National Infrastructure Planning
Temple Quay House
2 The Square
Bristol, BS1 6PN

Our Ref: EN010121

Date: 27 June 2024

Application by Morecambe Offshore Windfarm Ltd for an Order Granting Development Consent for the Morecambe Offshore Windfarm Generation Assets project.

**Title:**  
Offshore Statutory and Non-Statutory  
Nature Conservation Sites

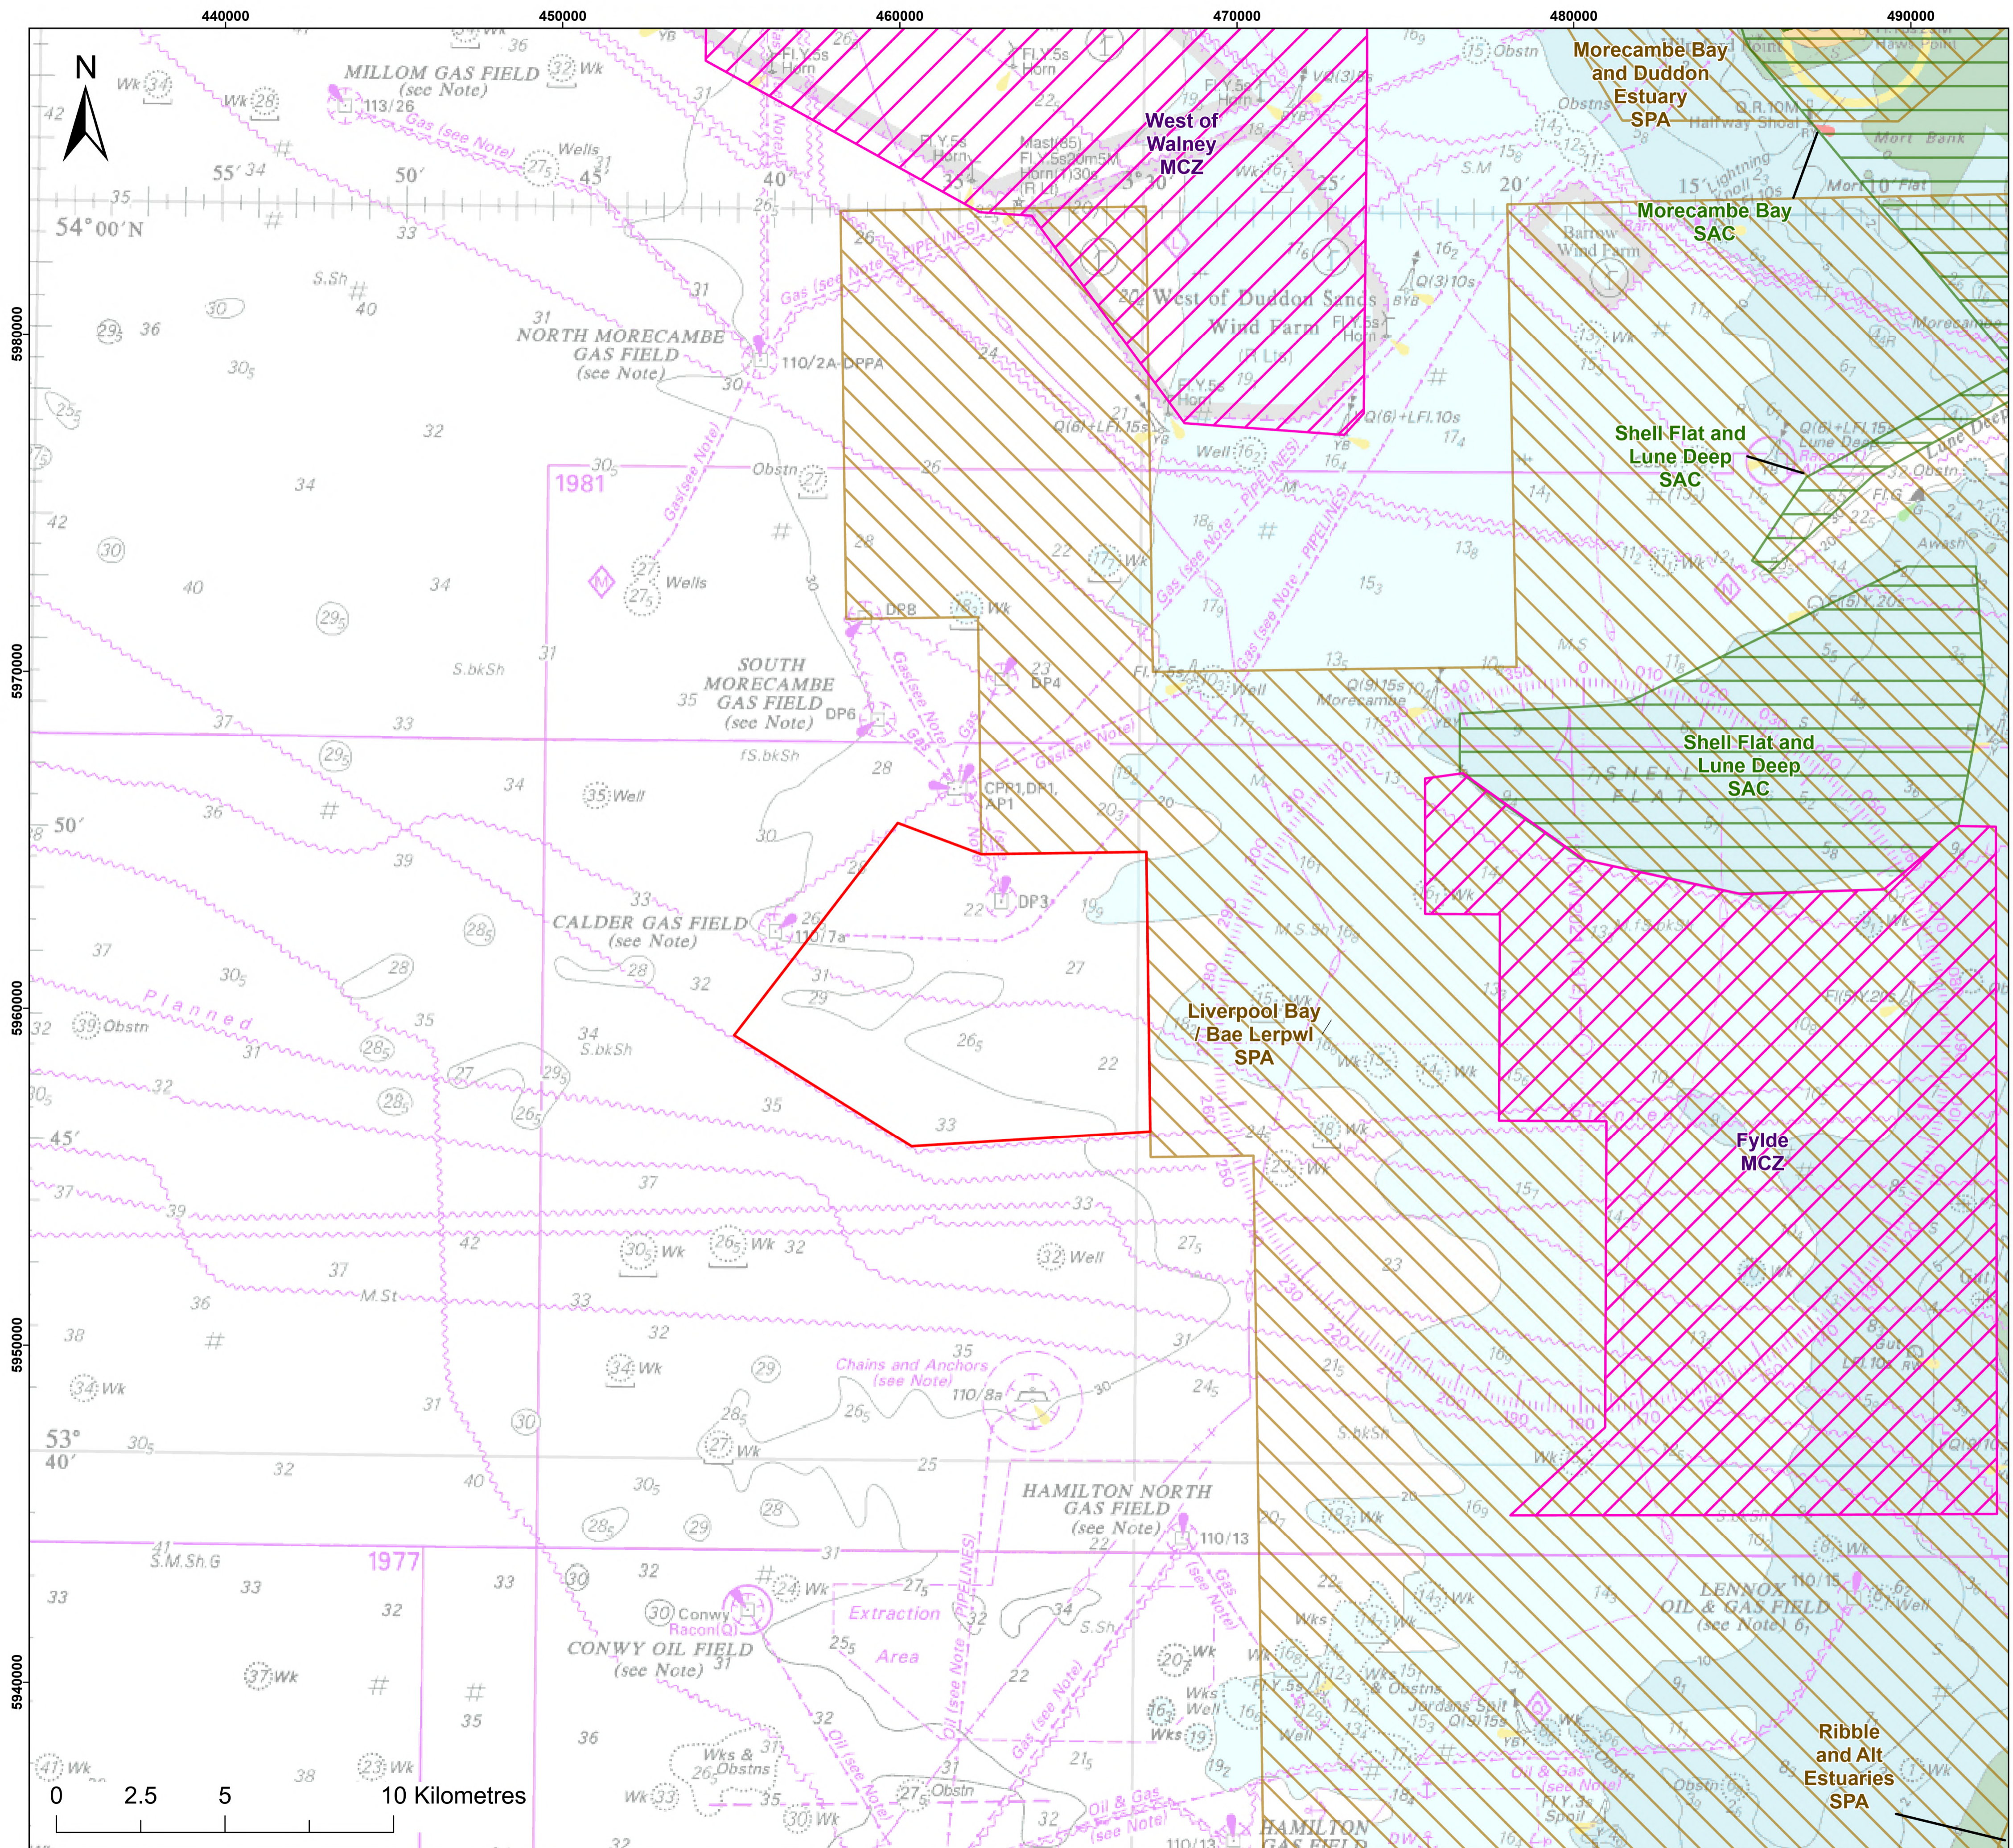
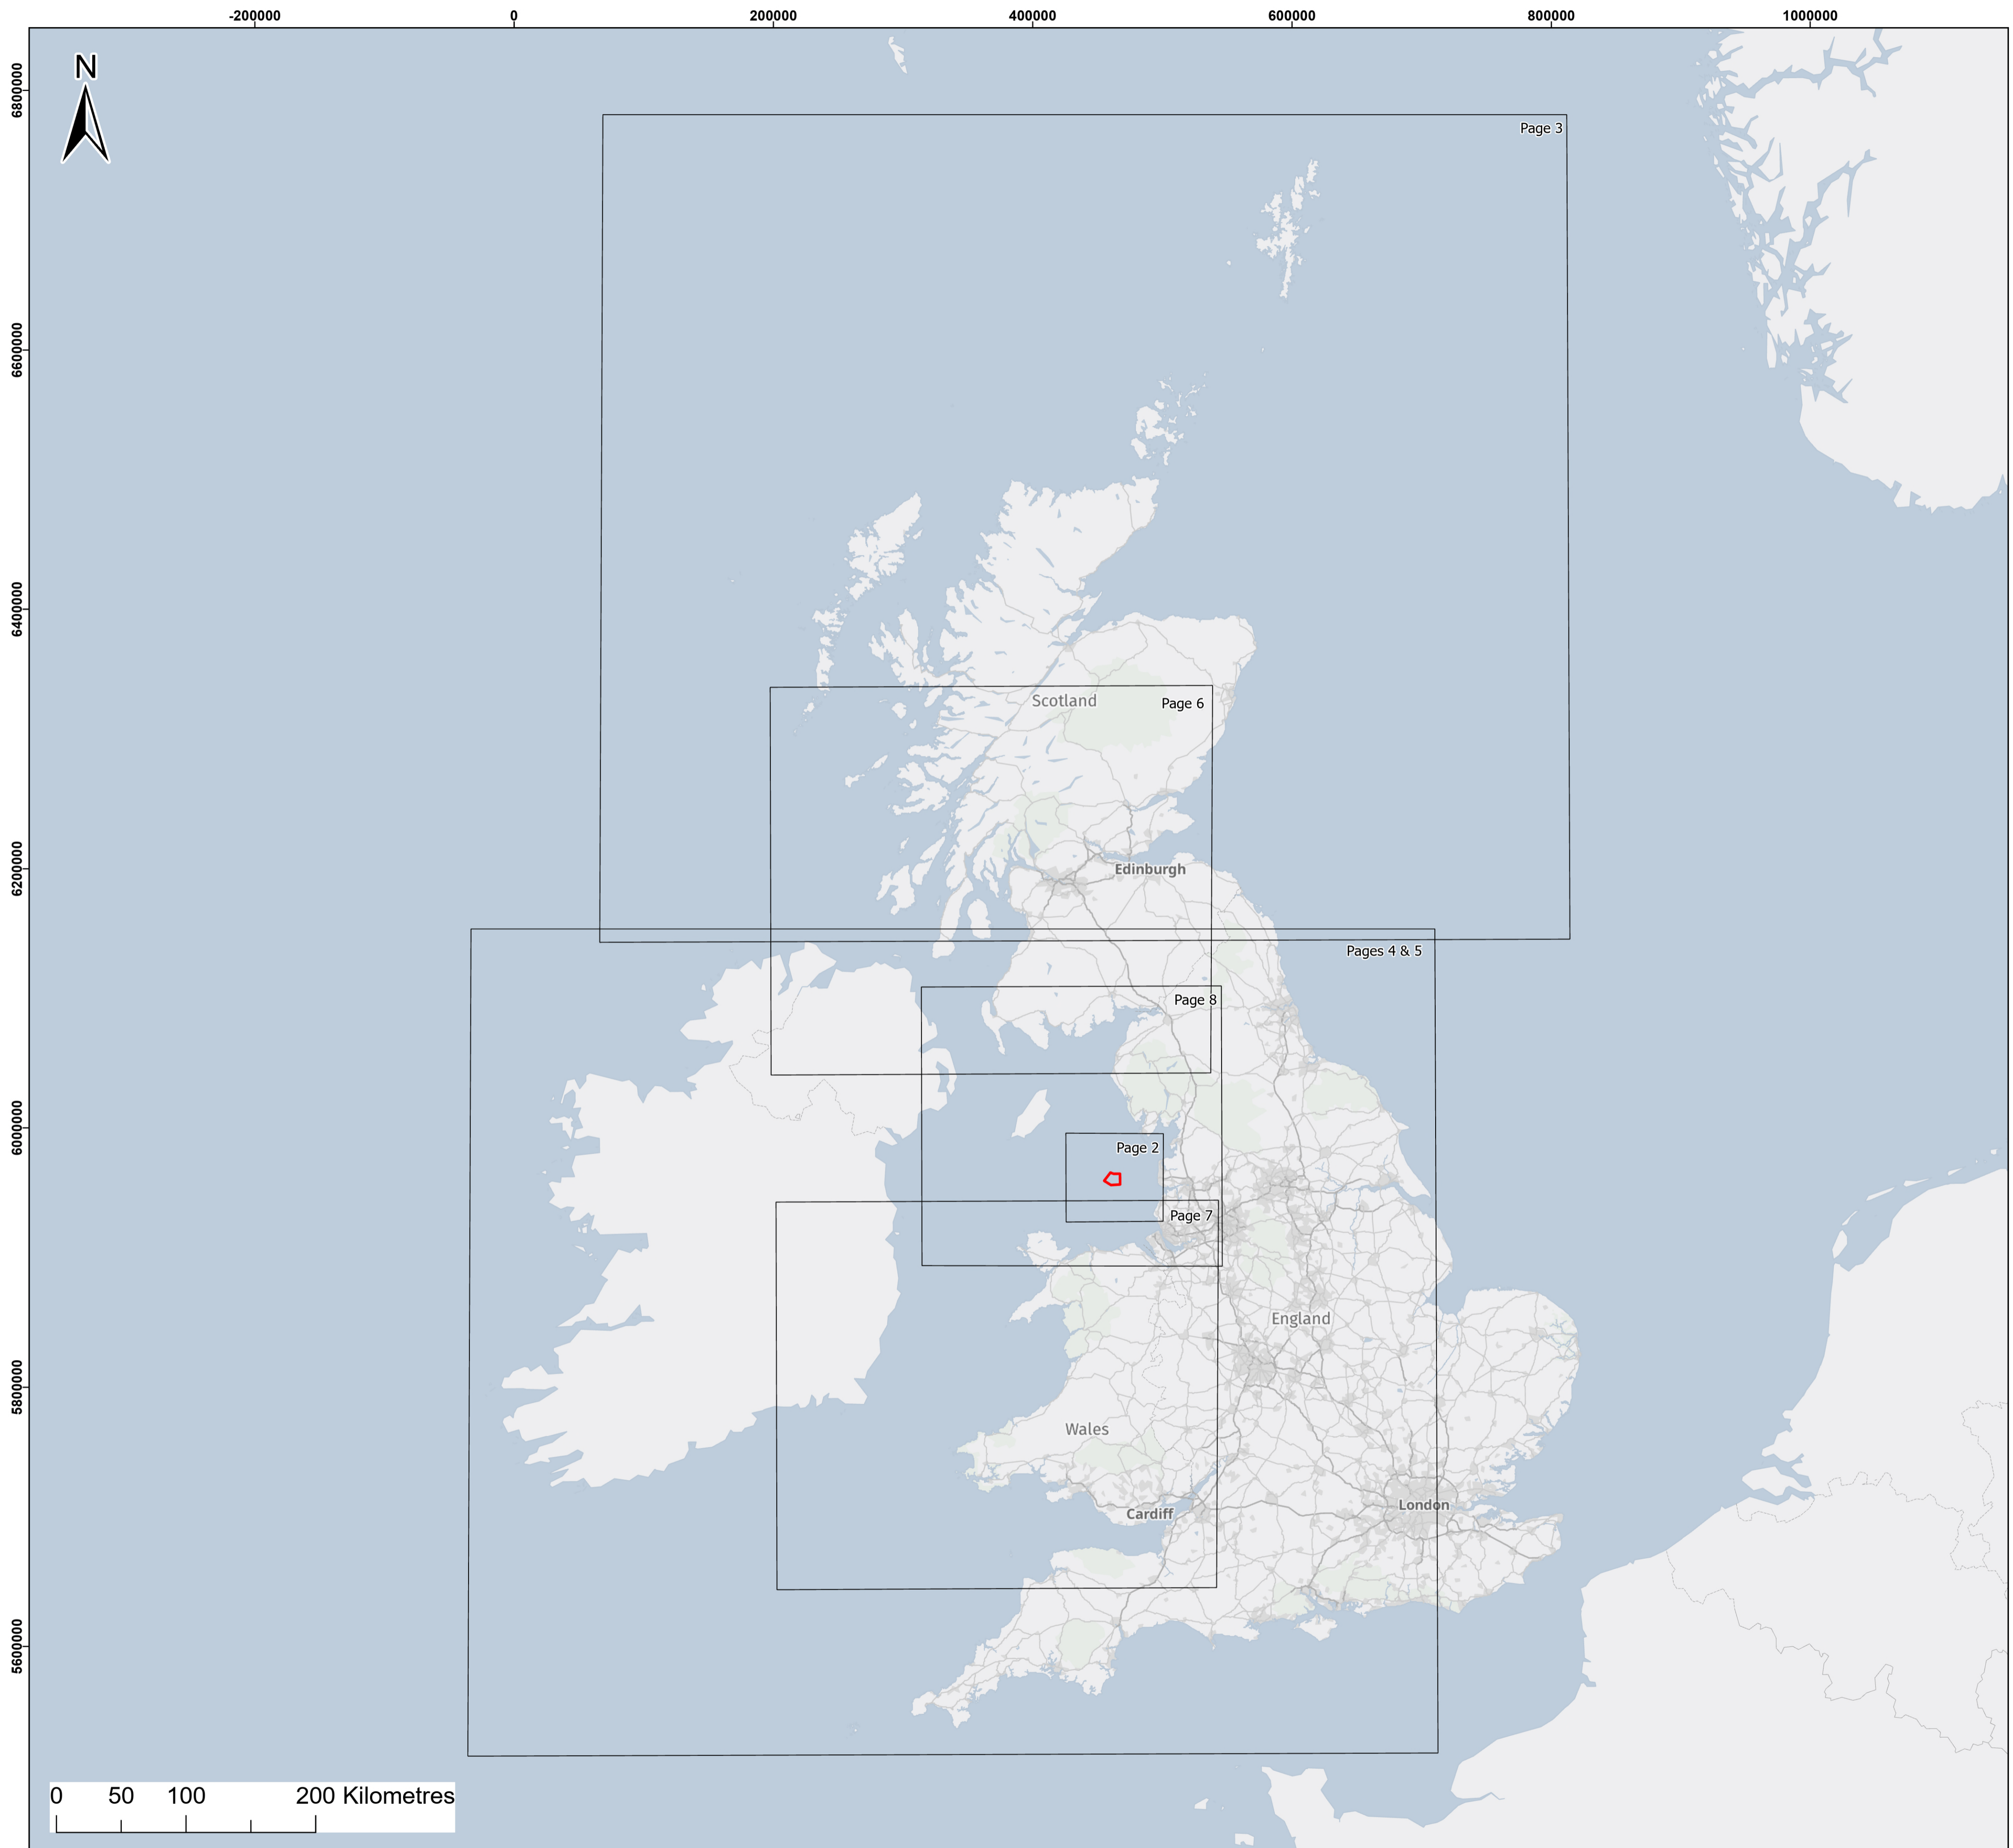
Noting comments in the section 55 checklist, at box 30, the Applicant is requested as soon as possible, to provide the Inspectorate with a plan or a series of plans (noting the

scale required) showing all the statutory and non-statutory designated sites that have been considered as part of the application.
